Application for Planning Permission for Works or Extension to a Dwelling

Development: Rear single storey extension and conversion of first floor loft space with rear facing dormer extension.

Location: 117 Harbour View Road Pagham PO21 4RJ

SITE PLAN - 1:500 @ A4

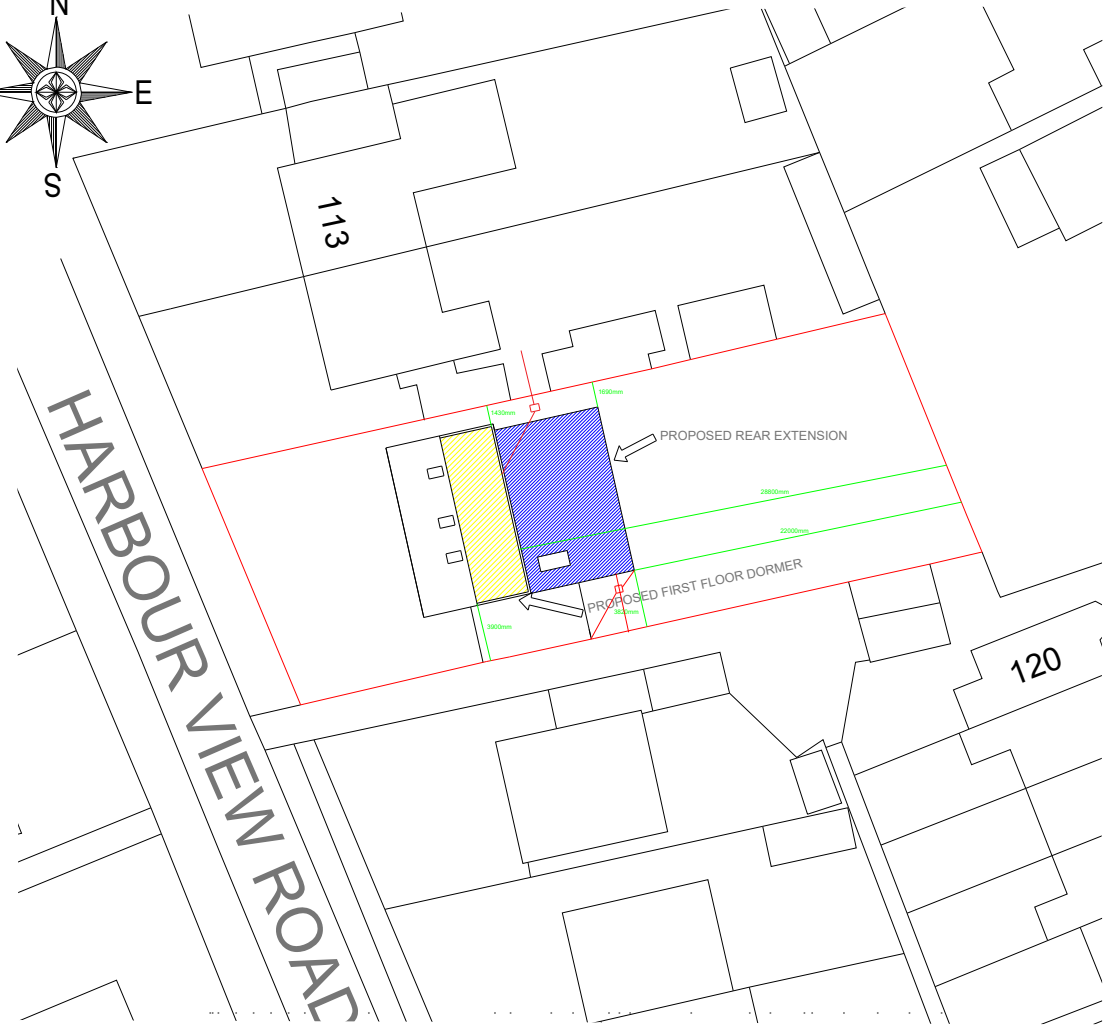
Please add a scale bar to the site plans.

EXISTING GROUND FLOOR PLAN

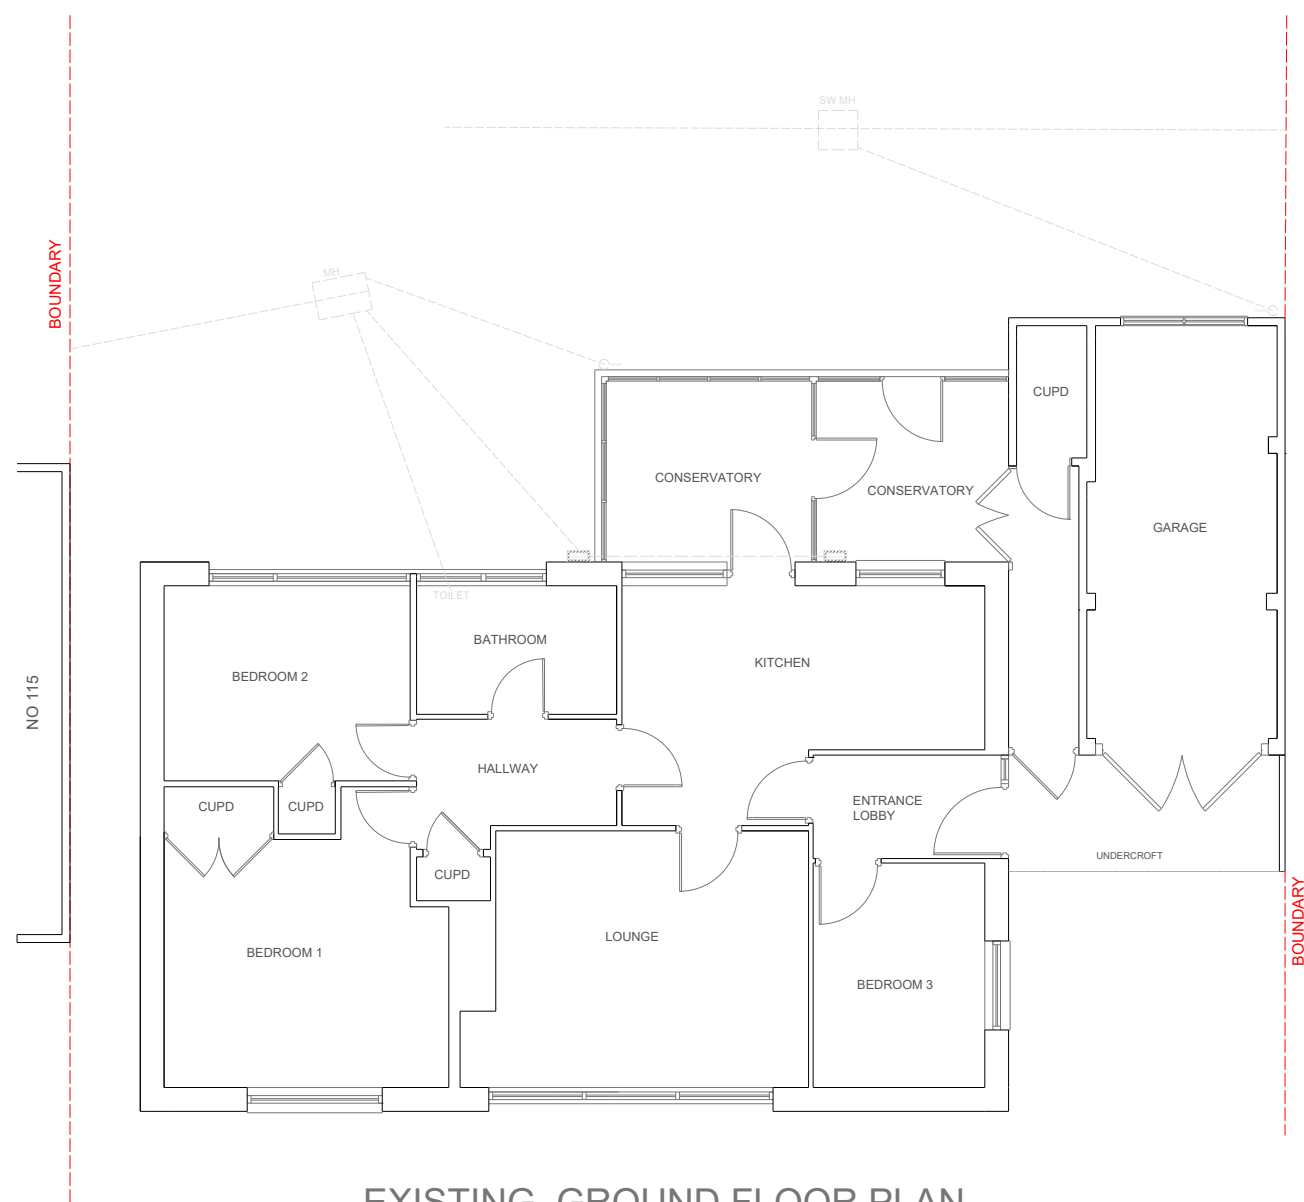
Please submit electronic plans in pdf format clearly labelled existing and proposed ground floor plans at a scale of 1:50 or 1:100. Further details can be found in the Validation Requirements List.
